Reference: #16S900100

30 November 2017

RE: 12 FREDERICK STREET, ST LEONARDS (SSD 7543 AND 8499)
RESPONSE TO COUNCIL COMMENTS

Figure 20: Proposed vehicle access (Base source: Tower A RtS podium level plan)

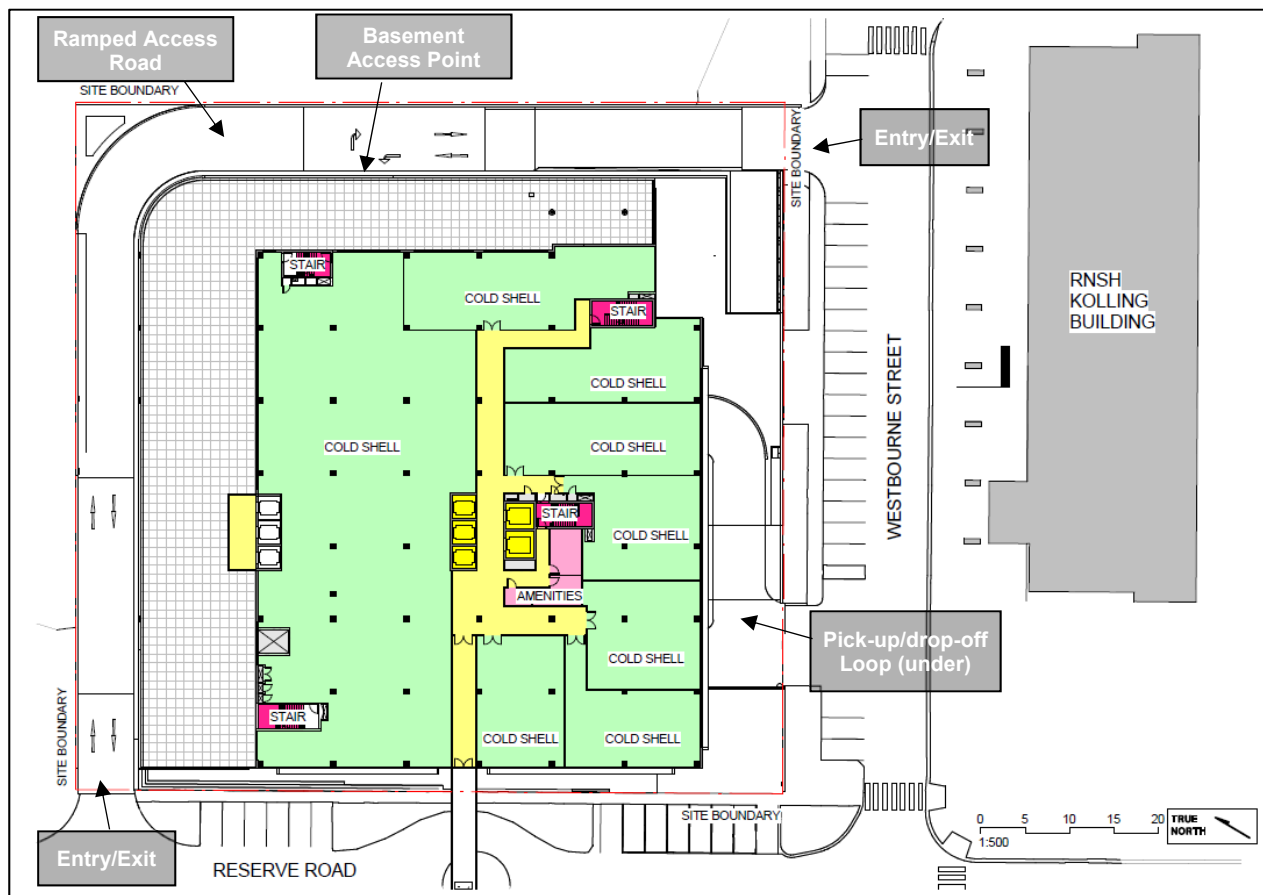
Council recommends that the architectural plans be amended to address the issues identified with the loading vehicles prior to the determination of the application. The architectural plans should also be reviewed to reduce the number of on street car parking spaces lost by the proposed development, particularly disabled parking.

A design compliance review and swept path assessment has been completed for the revised scheme, which includes some adjustments to the forecourt and loading dock to respond to Council comments and the internal building layout changes. The revised scheme provides better separation of the loading dock from the car park entry. Overall, the car park, loading dock and vehicle access points are capable of complying with AS2890 and can be conditioned accordingly.

The project team has reviewed the proposed vehicle access locations and note that it would be difficult to materially reduce the overall on-street car parking impact without reducing sight lines and corresponding safety outcomes.

It is noted, however, that the proposed development would replace the on-street lost within the basement car park. Additional disabled parking would also be provided (noting also that the new Royal North Shore Hospital multi-storey car park has opened since the on-street disabled parking was implemented and provides further disabled parking). As previously noted, the publicly accessible component of the proposed on-site car parking would effectively form part of the broader parking supply for the health precinct. The complementary nature of the proposed uses within the development are likely to result in a proportion of linked trips associated with both the existing North Shore Private Hospital, Royal North Shore Hospital and ancillary facilities. As such, there would be no net impact on the existing on-street parking supply.
